Abercrombie Precinct Redevelopment Project – Response to Submissions

Project Application (07_0158)

elevations :

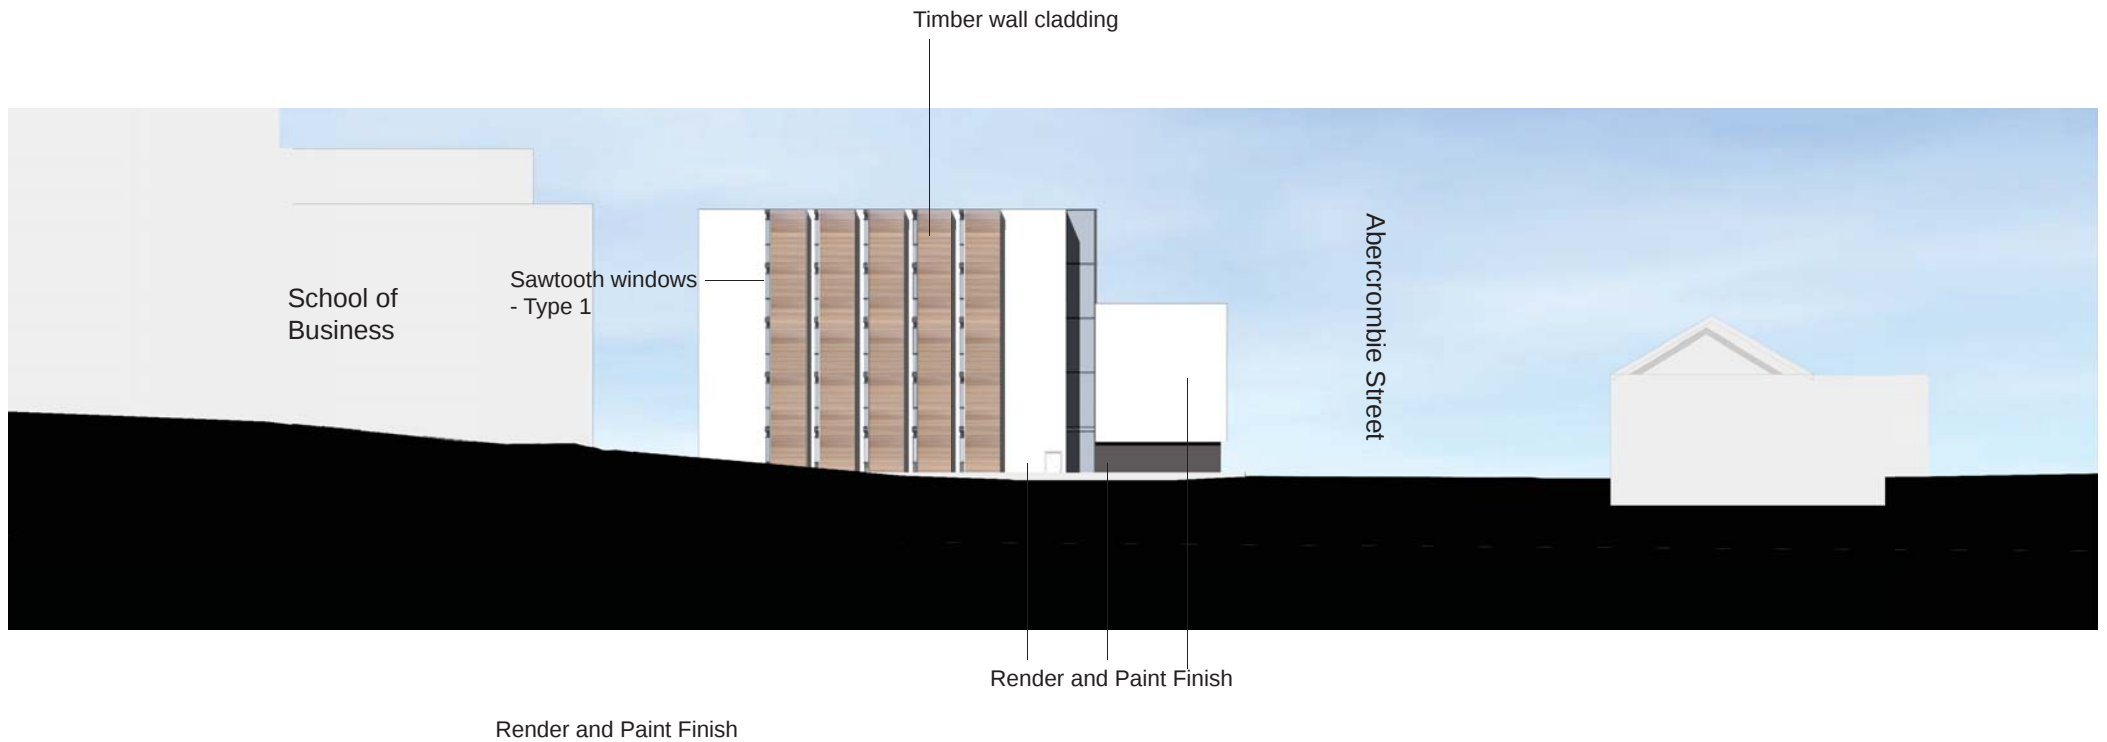
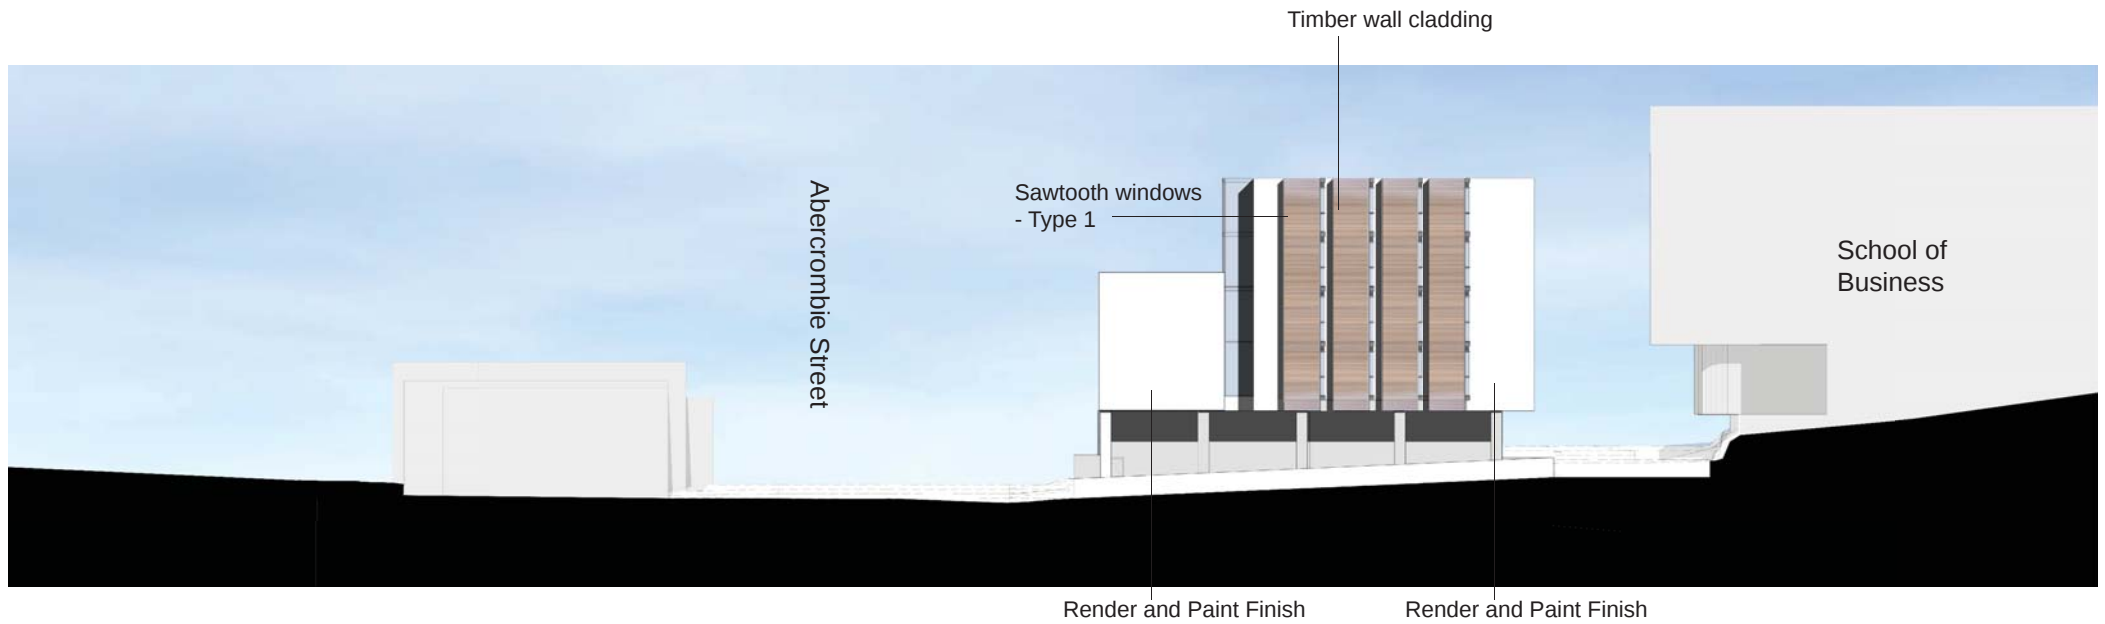
Further consideration should be given to the design and massing of the proposal along the western elevation of the proposal.	<p>The western elevation of the proposal has been modified as part of the revised scheme. The proposed modifications are discussed at Section 2.2 of the PPR. The Business School has been reduced to a height of 4 storeys at the boundary with Darlington Public School, compared to the maximum of 6 storeys that was originally proposed. The Business School has also been broken down into two distinct elements along this frontage, providing greater articulation when compared to the single building that formed part of the original design. The revised scale and massing will reduce the visual dominance of the development when viewed from within the School grounds, and will also mitigate against overshadowing.</p> <p>The student accommodation building forms a smaller element of the frontage to Darlington Public School, occupying approximately 30% of the site's boundary (30m of the 107m frontage).</p>

<p>Greater vertical articulation and relief in the built form should be provided to the Abercrombie Street elevation to reduce the dominance of the elevation within the existing streetscape.</p>	<p>As discussed at Section 2.1 of the PPR, the Abercrombie Street elevation comprises three separate elements, which in themselves serve to reduce the dominance of the development:</p> <ul style="list-style-type: none"> ■ the Business School; ■ the student accommodation building; and ■ Mandelbaum House (existing building to be retained) <p><i>Business School</i></p> <p>The southern elevation of the Business School presents as six vertical elements, ranging in height from 4 to 6 storeys. The two elements that front onto Abercrombie Street are setback some 18m from the street frontage at ground level. The increased setbacks provide for significant landscaping opportunities on the Abercrombie and Codrington Street frontages.</p> <p>The remaining four elements of the Business School are located behind Mandelbaum House and the new student accommodation development, and will not be visible from Abercrombie Street, except where glimpses are afforded through or above these two buildings. By siting the taller elements away from the Abercrombie Street frontage, the massing will more appropriately reflect the smaller scale of the adjacent development and visual impacts on the conservation area will be minimised.</p> <p><i>Student Accommodation</i></p> <p>The proposed student accommodation building forms a significant component of the Abercrombie Street elevation. By positioning the student accommodation building on the Abercrombie Street frontage, it acts as a link to the community and provides a building that is of a residential character and scale at this interface.</p> <p>The student accommodation building comprises 5 storeys, and has been designed by Nettleton</p>

Streetscape Character	
The strong horizontal lines of the exposed slabs that have been expressed on the street elevations fail to adequately respond to the fine-grain vertical character of the surrounding streets, and particularly along Abercrombie Street.	Refer to above / earlier commentary.
The architectural character of the perimeter of the building needs to be amended by the incorporating strong vertical articulation to ensure the buildings along Abercrombie Street harmonise with the character of the Victorian terraces.	Refer to above / earlier commentary.
It is noted that in order to assist in achieving a successful integration with the surrounding context, the proposed student housing component of the development has been deliberately located to face Abercrombie Street to complement the residential uses in the precinct. Similarly, at the south-eastern corner of the building complex at the intersection between Abercrombie Street and Codrington Street, a café is to be provided which will supplement the other cafes that exist along the street.	Noted. These design elements have been maintained as part of the revised scheme.

<p>Tribe to ensure a different design aesthetic is achieved, when compared to the Business School. This will assist in breaking down the apparent massing of the development when viewed from Abercrombie Street. As detailed in Nettleton Tribe's Design Statement at Appendix D, the overall mass of the facade has been divided into three horizontal sections (a classic base, with middle and top articulation) in a 1 / 3 / 1 proportion. The building has been further broken down into three distinct vertical sections with punctuations created by the stairs and study rooms.</p>
<p>Further visual analysis of the proposal within the context of the surrounding locality is required, including the provision of photomontages from the following perspectives:</p> <ul style="list-style-type: none"> ▪ Golden Grove Street, looking east across the existing recreational areas of Darlington Public School; ▪ Intersection of Golden Grove Street and Abercrombie Street, looking east; and ▪ Abercrombie Street, looking west just beyond the western side of the intersection of Abercrombie Street and Codrington Street. 	<p>A series of photomontages are provided at Appendix C. The Visual Analysis at Section 2.6 of the PPR demonstrates that the development sits comfortably within the locality when viewed from these locations.</p> <p><i>Golden Grove Street, looking east across the existing recreational areas of Darlington Public School</i></p> <p>From this location, the the development is largely obscured by mature vegetation in the foreground and along the School's eastern boundary. When viewed from within the School site, the Business School and student accommodation will present as three distinct building elements. The Business School, which has a longer frontage along this boundary, is limited to 4 storeys. The student housing development, which has a much smaller frontage to the School, comprises 5 storeys.</p> <p><i>Intersection of Golden Grove Street and Abercrombie Street, looking east</i></p> <p>The photomontage demonstrates that the student housing is not incompatible with the scale of surrounding development (predominantly Darlington Public School). The visual impacts of the development are reduced through the provision of articulated façades, the use of sympathetic materials, and by maintaining existing street trees.</p> <p><i>Abercrombie Street, looking west just beyond the western side of the intersection of Abercrombie Street and Codrington Street</i></p> <p>In addition to the reduced heights and the articulation of the façade, the visual impact along Abercrombie Street has been softened through the use of colours, materials and textures that break down the mass of the buildings.</p>
